# CITY OF ALBUQUERQUE

April 30, 2013

RE: Mitchell Elementary - School Cafeteria Addition  
Grade & Drain Plan for SO-19 & Building Permit

**G21-D033**

CG-101

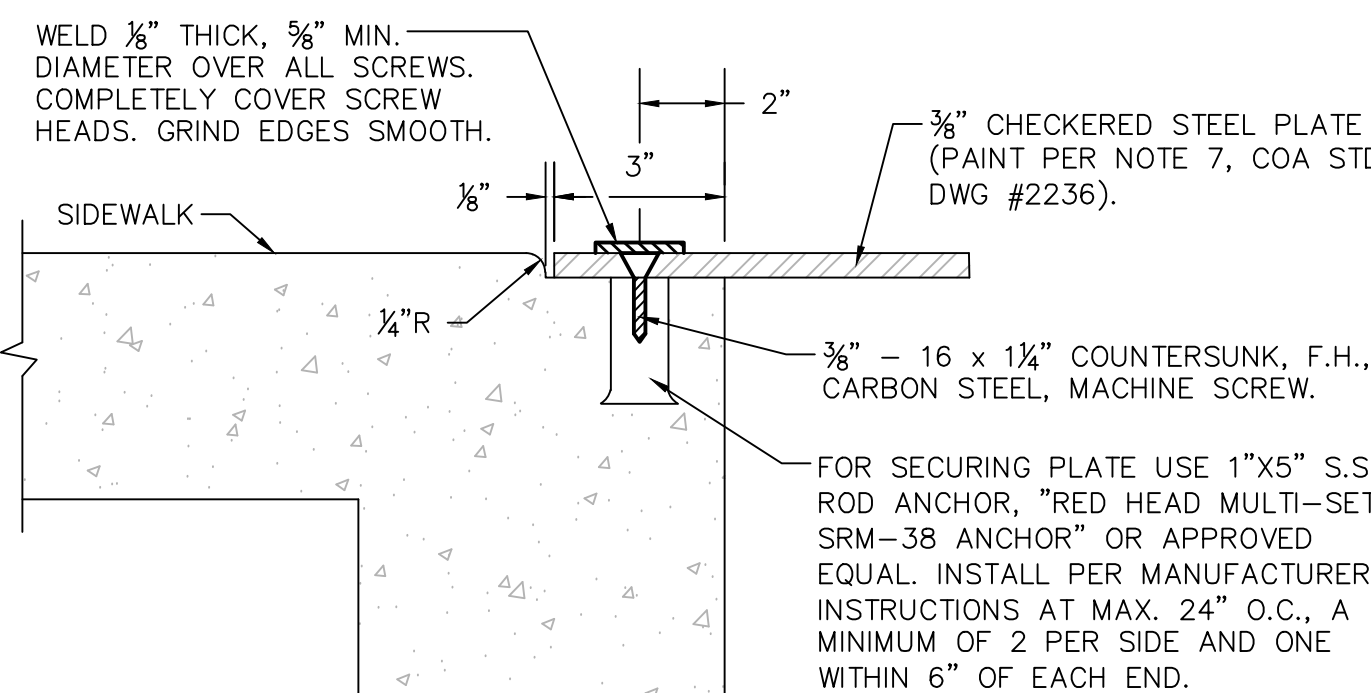
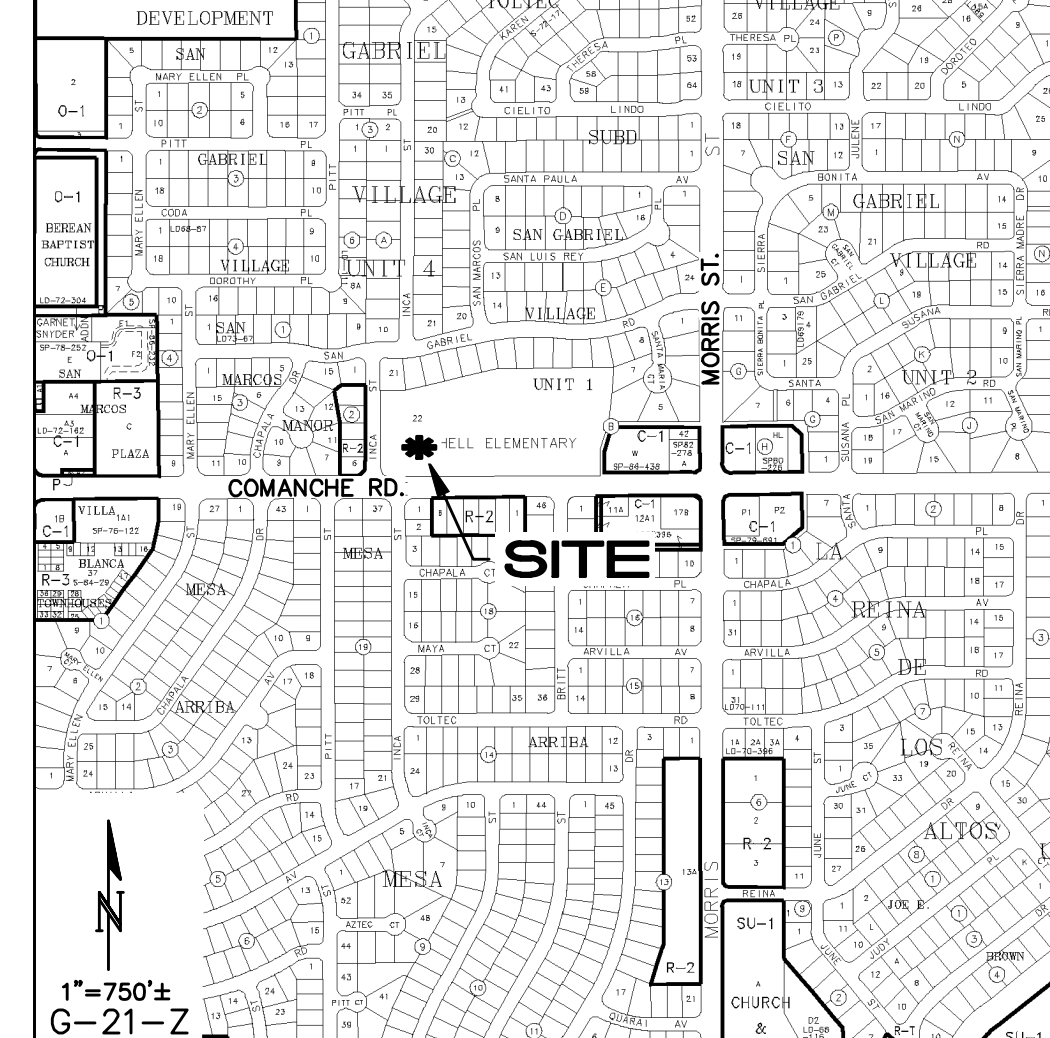
1. The sidewalk culvert should extend two feet east from back-of-sidewalk on Inca.
2. Provide culvert capacity calculations for the proposed sidewalk culvert.

3. Please enlarge or deepen the Water Harvesting area along Inca to help mitigate the increased discharge due to the new development on site.
4. At the discharge end of the private storm drain, show the referenced "Splash Pad" and provide flow rate or minimum swale armoring specs for Landscape Improvements.

5. Note that the western 6'-8' of the 8" private storm drain will be exposed above grade, and may be subject to further exposure by possible erosion from the proposed swale along its southern side. Please review and adjust as needed.

6. Keyed Notes (10) and (12) near Inca are not located correctly on the plan.
7. Clarify the proposed improvements at the east side of the building addition, "Gravel" vs. "Concrete."

8. Note that the Trench Drain design calls for a K900 Inline Inlet, but I found that the K900 Inlets do not have cut-outs for the 8" size outfall proposed.
